## Application for a Non-Material Amendment Following a Grant of Planning Permission

ERECTION OF DETACHED GARAGE WITH GAMES ROOM ABOVE

22/0705/HOUS

ONE STOREY ONLY NOT ONE AND A HALF (NO GAMES ROOM ABOVE) AND MATERIALS TO MATCH EXISTING DWELLING (BRICK NOT TIMBER CLADDING)

Dwg Title
Proposed Plans and Elevations

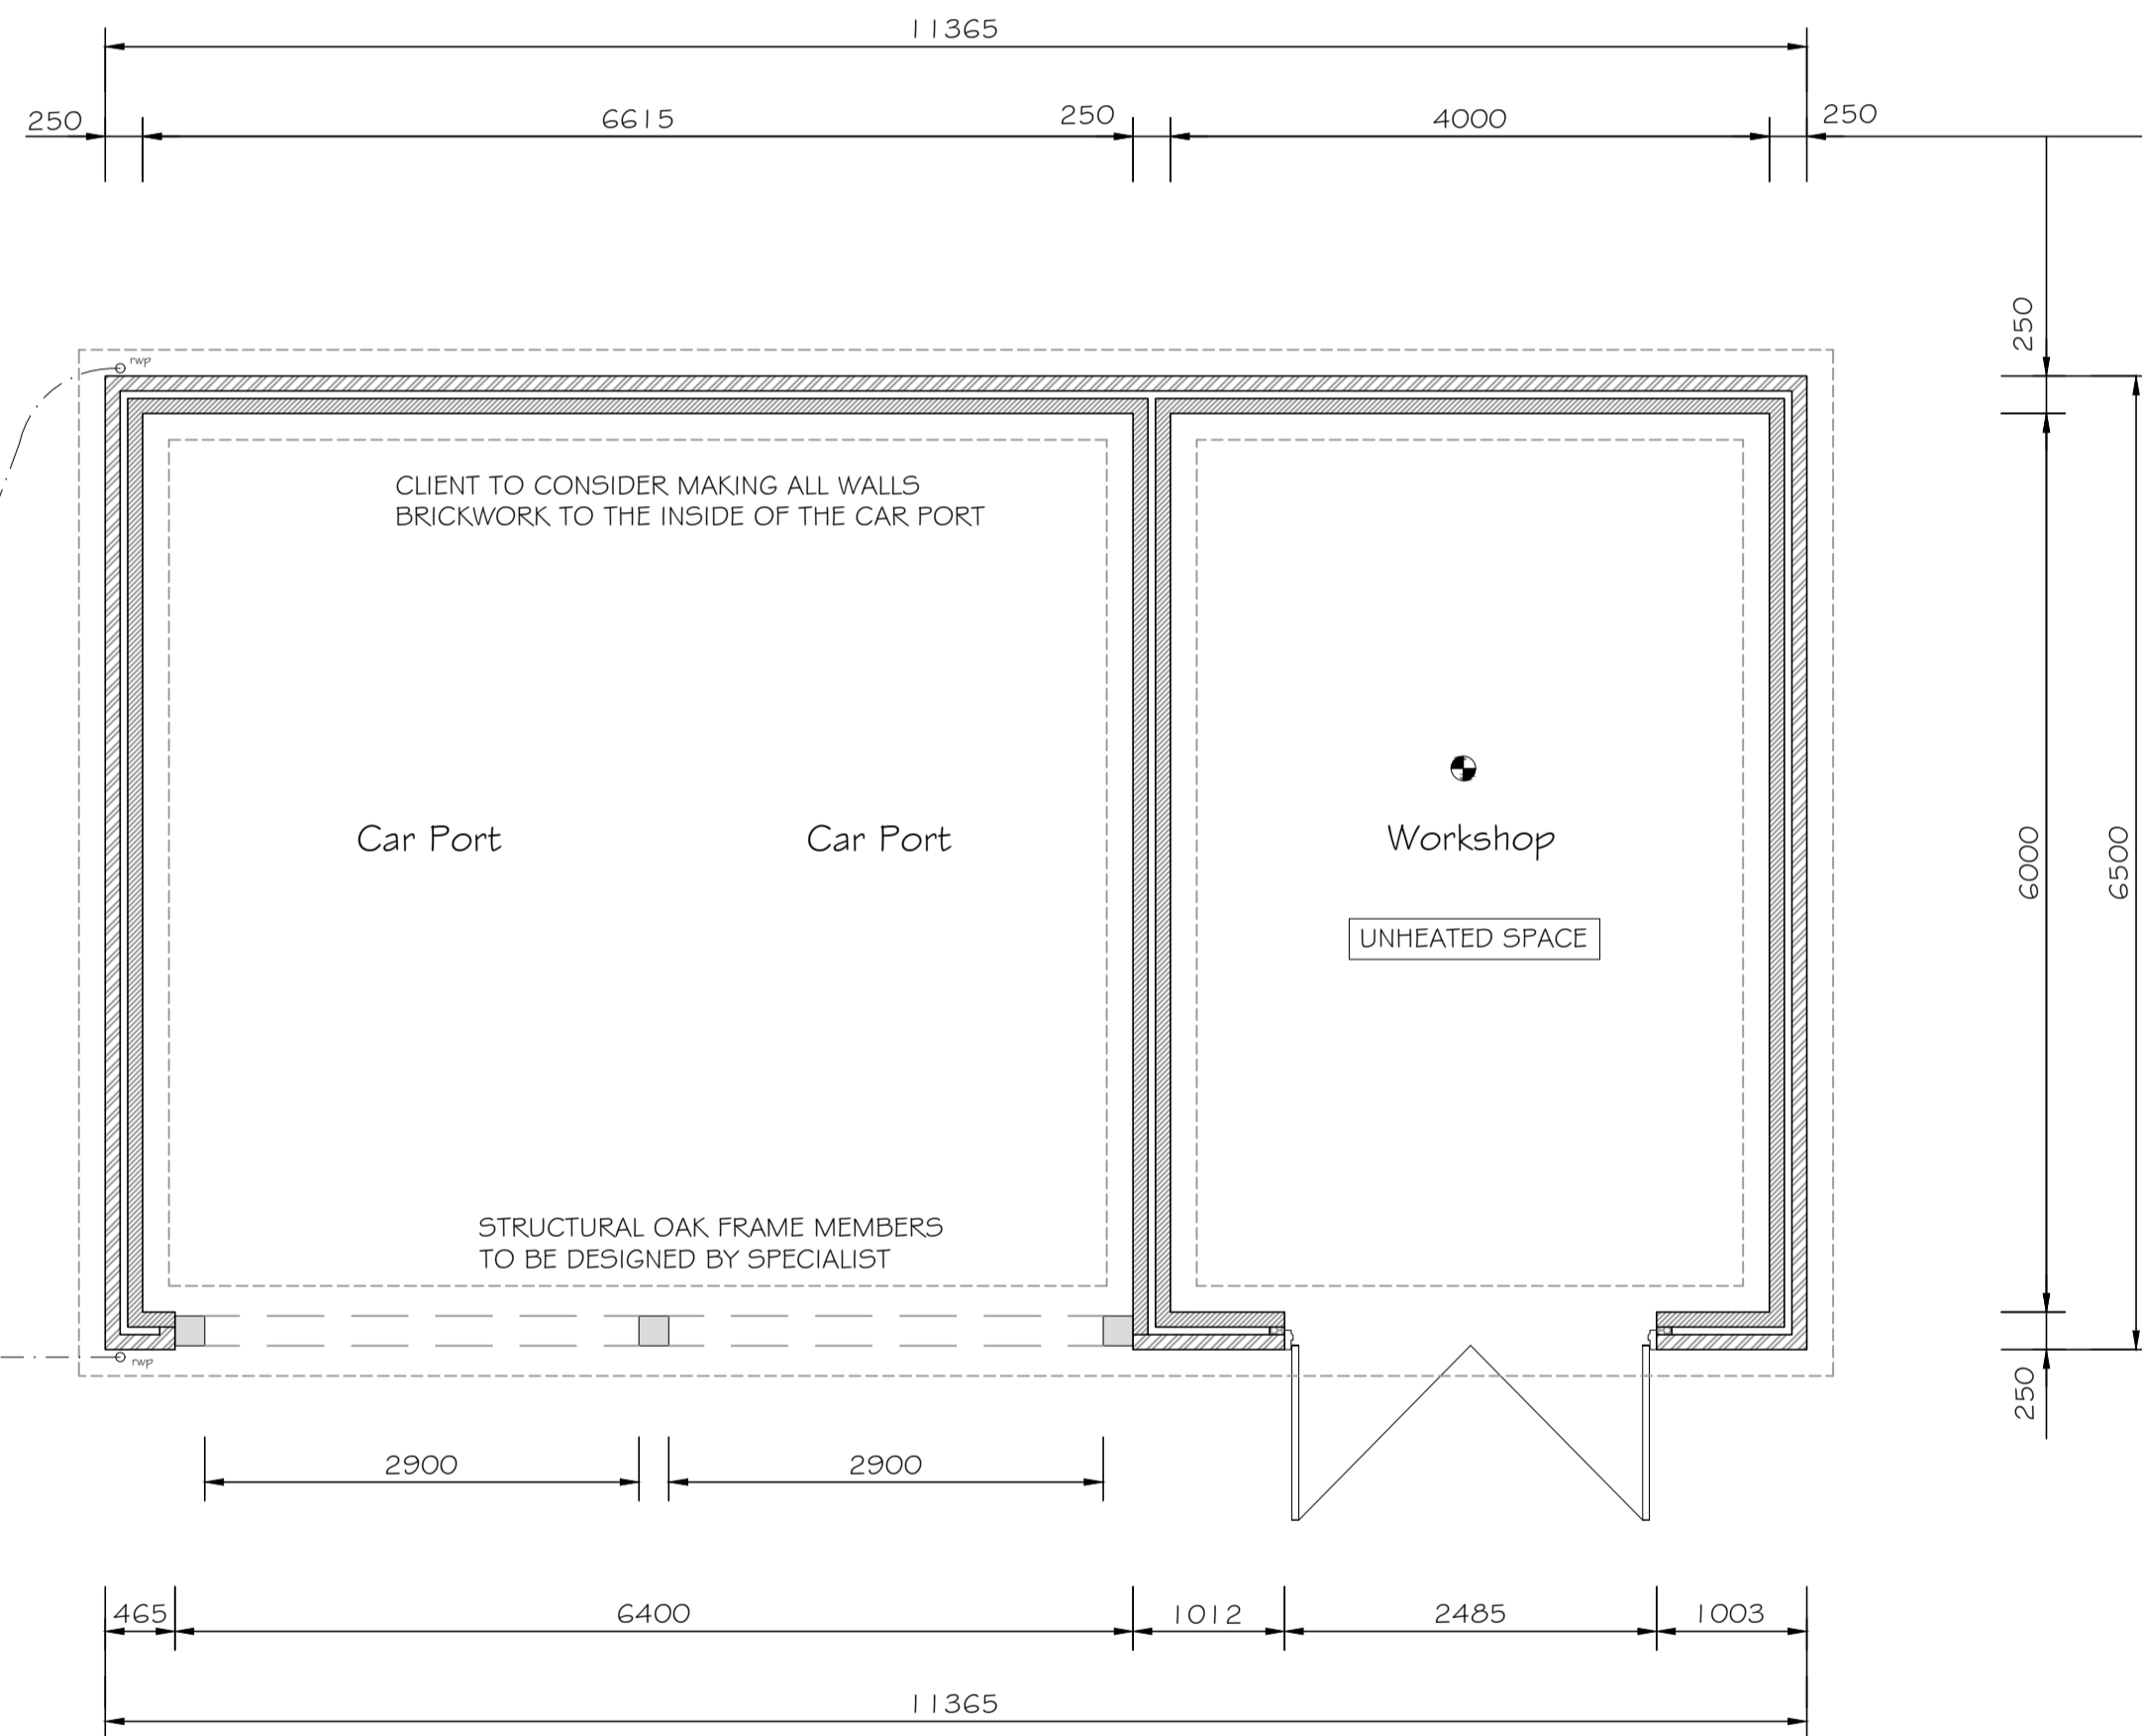
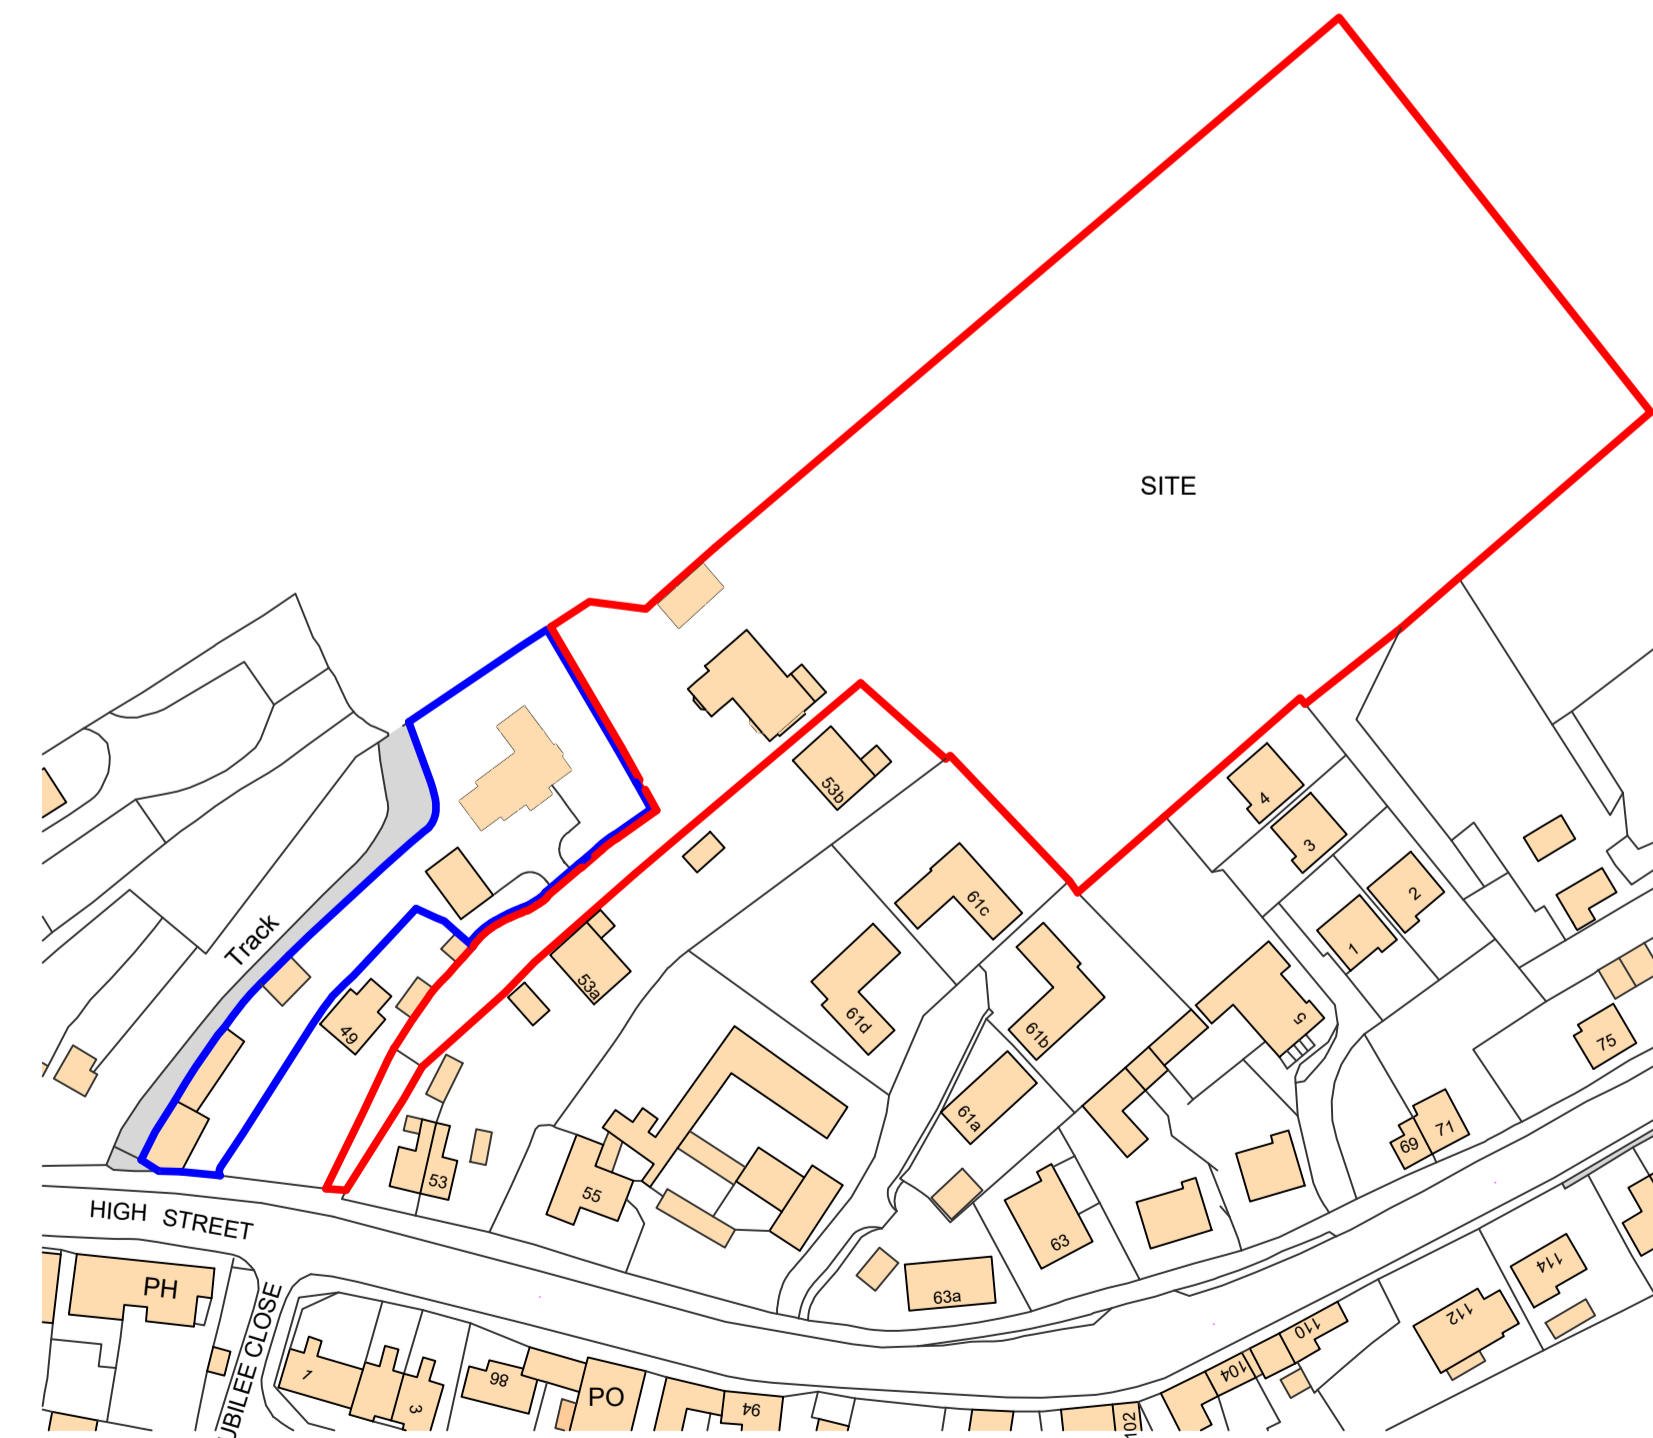
NEW DESIGN TO ECHO DESIGN AND LOOK OF EXISTING DWELLING
